Your Ref: OWPC4409
Our Ref: AL/75/14/OUT 06-10-2014
Please ask for:
Mr S Davis

Outline application with some matters reserved for a residential development to the west of the site comprising 2No semi detached three bed houses and 1No detached two bed bungalow with improved access off hook lane.

Woodgate Farm Westergate Street Aldingbourne

Thank you for your internet representation made on 2nd December 2014 which has been recorded as '**an objection**' with the comments as follows:

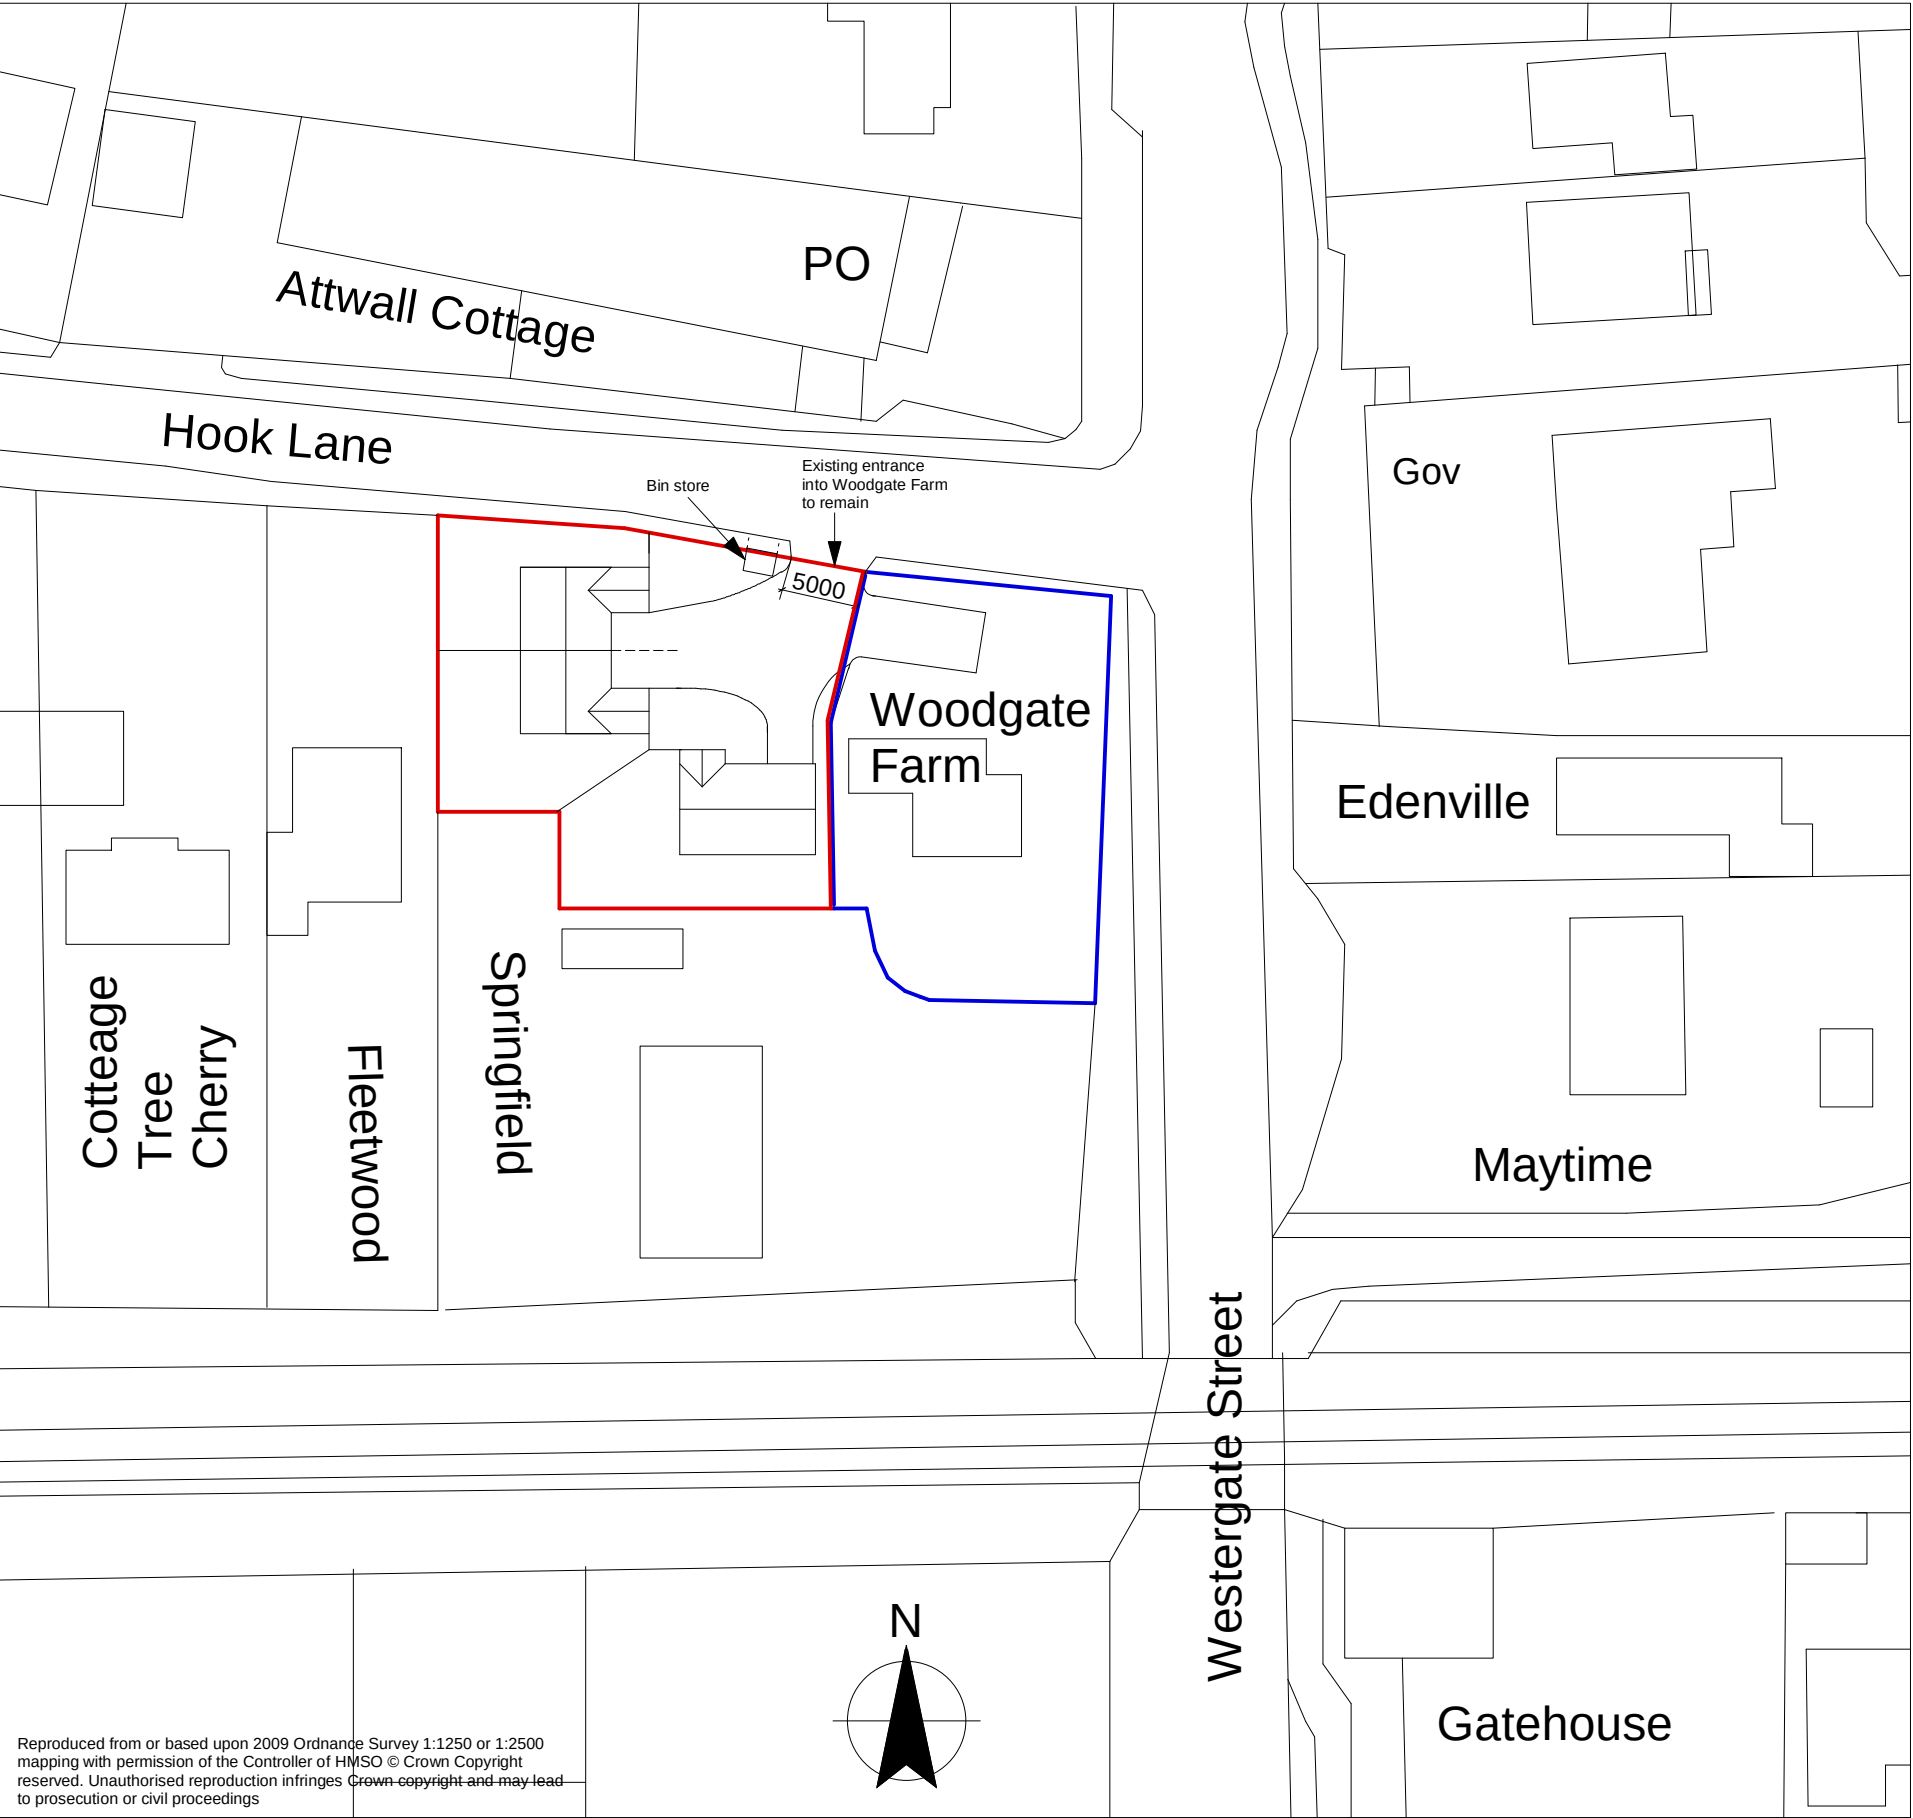
My objections are that it is an overdevelopment on the land available, and, also the access to the site is within approximately 10 metres of a major road (A29) and would constitute a very clear danger to vehicles accessing Hook Lane.
